**Consultation Response from KC,
Highways Development Management****2024/93156 Healey Lane Mills, Healey Lane, Healey, Batley, WF17 7SH****Outline application for redevelopment of existing Islamic Centre****Date Responded: 11/07/2025****Responding Officer: CNB****Responding Ref: K13-6SW/1**

This is an outline application with access, appearance, layout and scale for the partial demolition of a mill building, part change of use to community uses and the building of a mosque/madrassa with parking and access on to B6123 Healey Lane, a 30mph two-way single carriageway secondary link road of approximately 9.3m width with footways on both sides and street lighting present.

Drawing No: 21/382/ACC/001

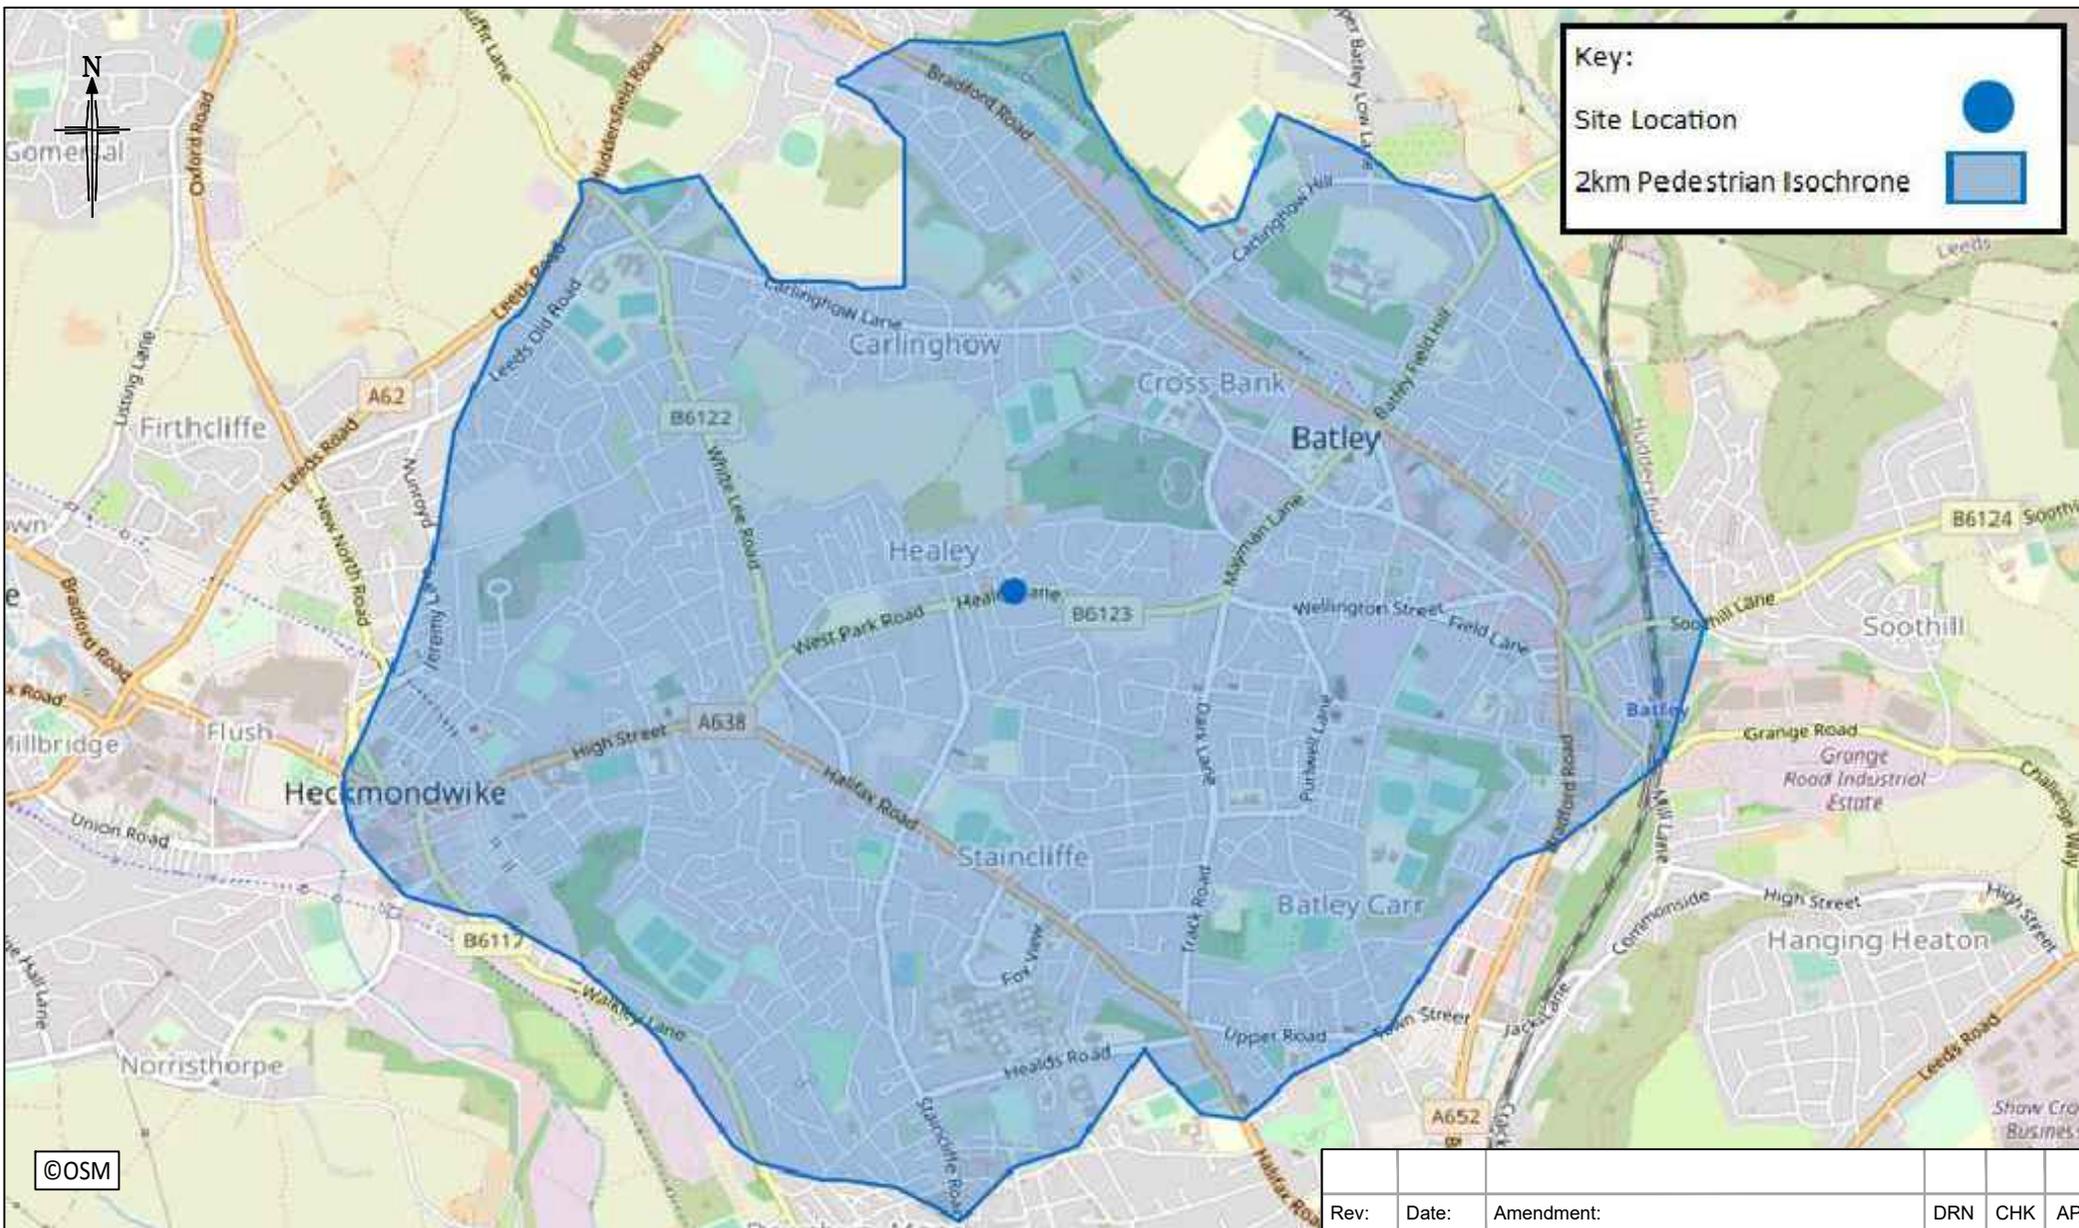
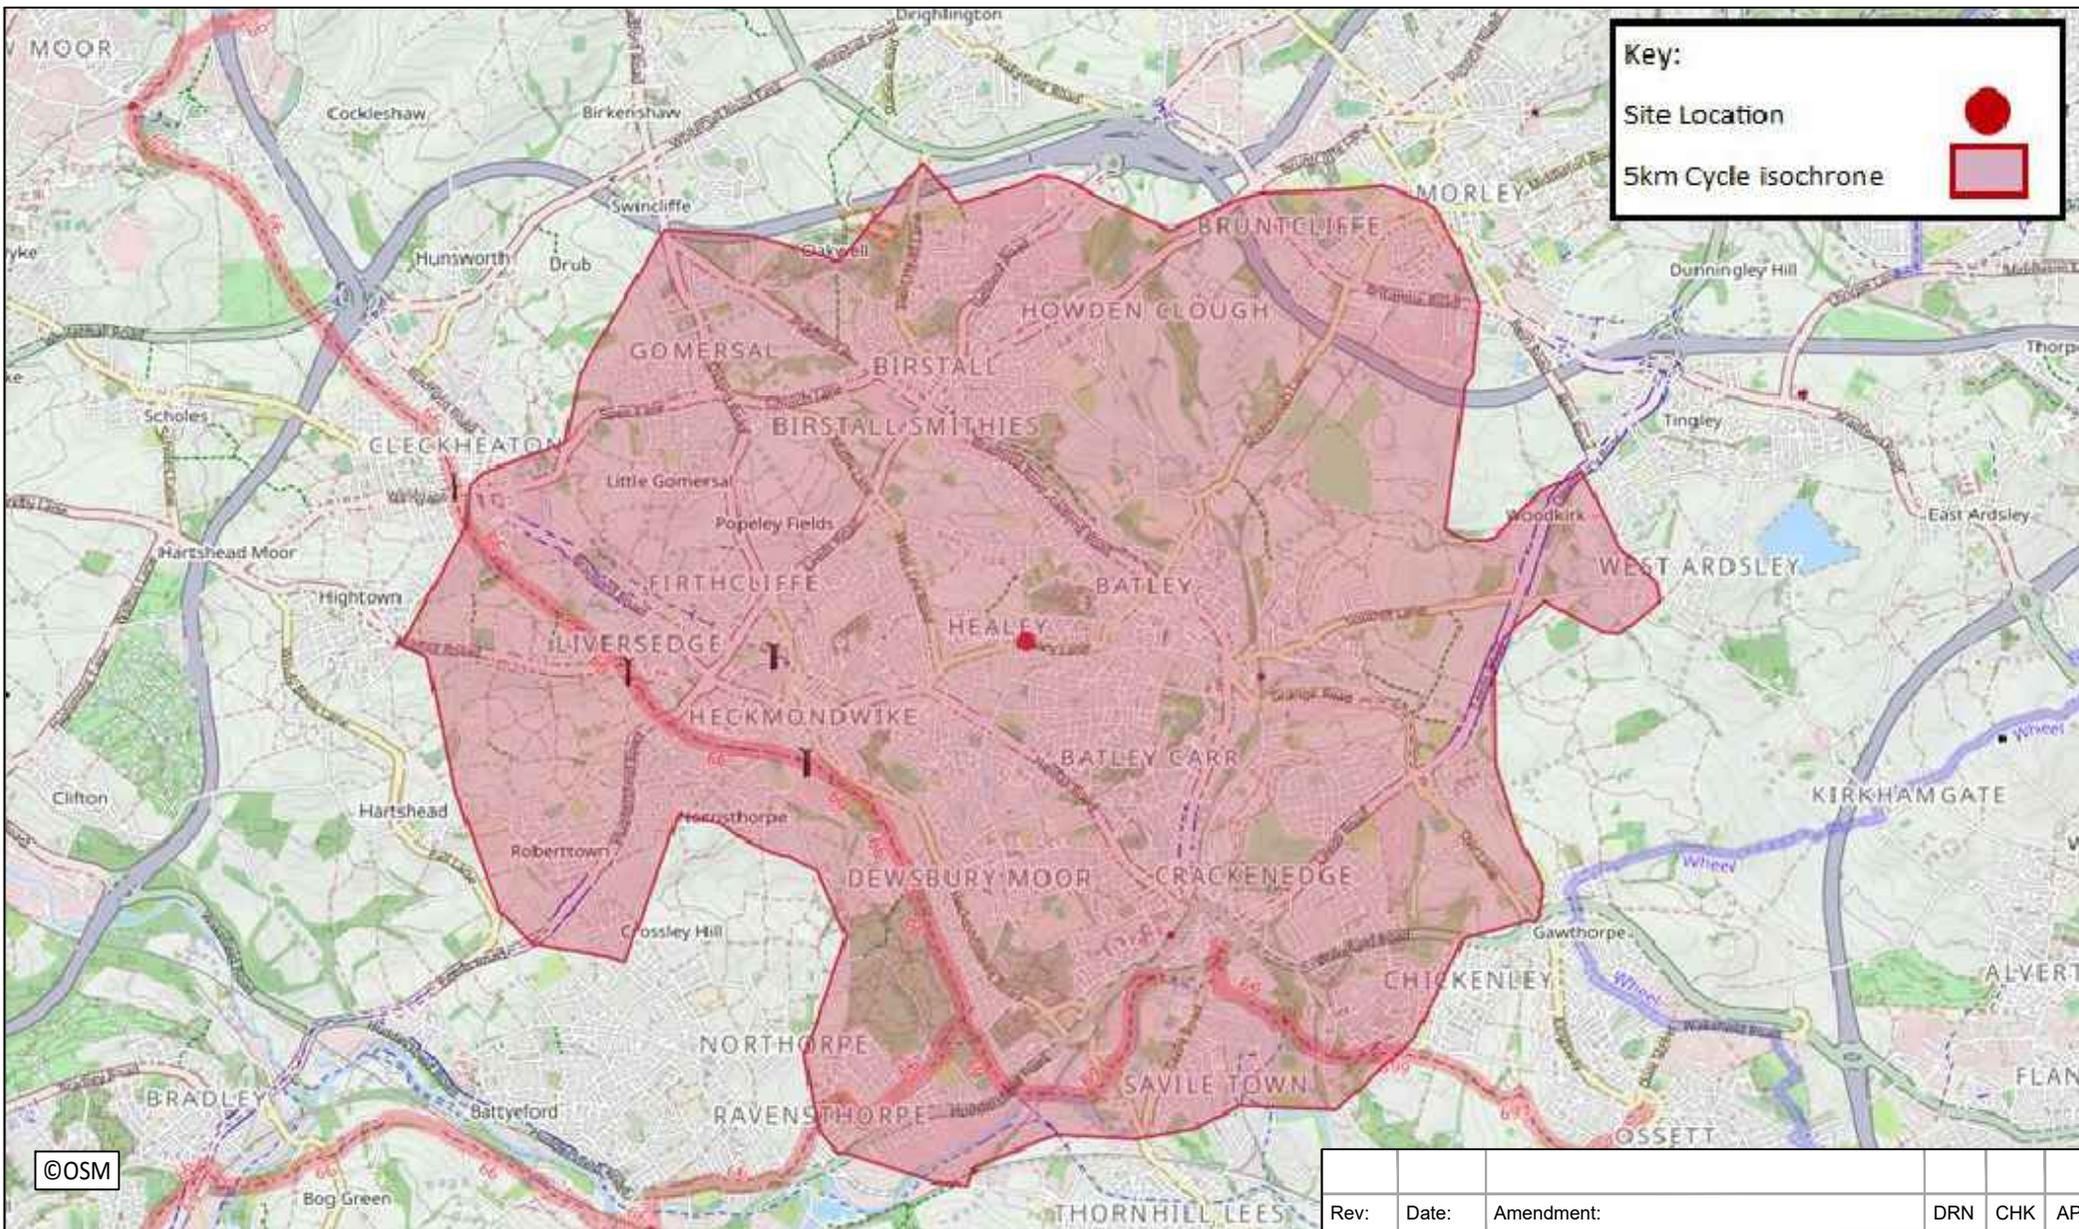
Two vehicular accesses are proposed, with an in/out circulation system through the car park proposed. The in access would be to the west of the proposal site while the out access would be to the east of the site. Both access points are existing but would undergo improvements. Any changes to the accesses would need to be carried out under the appropriate legal agreement with the local highway authority, either a s184 or a s278 agreement depending on the level of the changes/improvements required.

The one-way system should be clearly marked with either "ENTRY" and "EXIT", "IN" and "OUT" or arrow markings and this should be conditioned.

Before the development is brought into use the ingress and egress shall be signed and lined with suitable markings in accordance with with details that have been approved in writing by the Local
